# SEA LINK

EN020026

## Answers to Examining Authority Questions Round 3

Suffolk County Council

Drawing file: published-documents / EN020026-002825-9.122 Surface Water Flood Risk and Climate Change - Technical Note.pdf

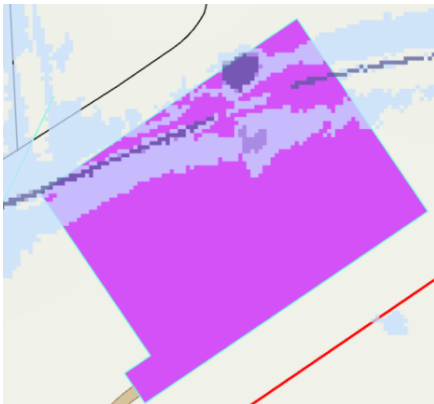
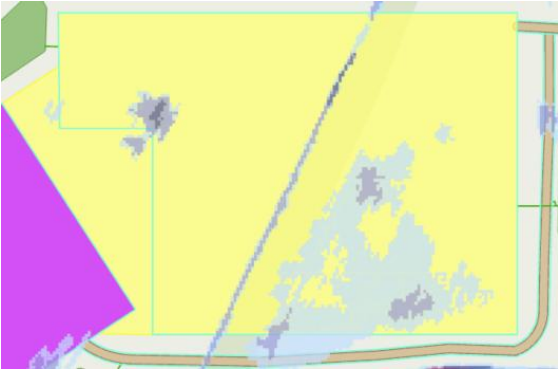
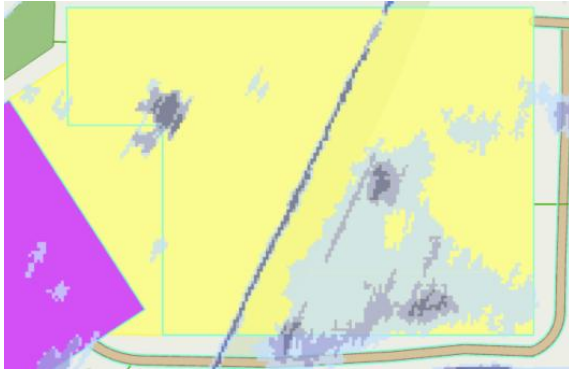
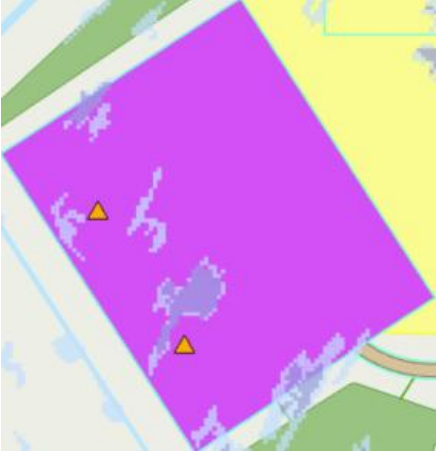
ExQ3	Question to:	Question:	SCC Answer:
<b>5 Water environment</b>			
3WE3.	SCC	<p><b>Flood Risk Assessment</b></p> <p>Does the applicant's Surface Water Flood Risk and Climate Change - Technical Note [REP5-134] address all outstanding concerns with respect to the applicant's Flood Risk Assessment? If not, what concerns remain and what additional information is required?</p>	<p>SCC, LLFA is generally happy with the submission, but the clarity of the mapping on pages 4 to 8 are not clear and they need to show the extend of the proposed developed area.</p>
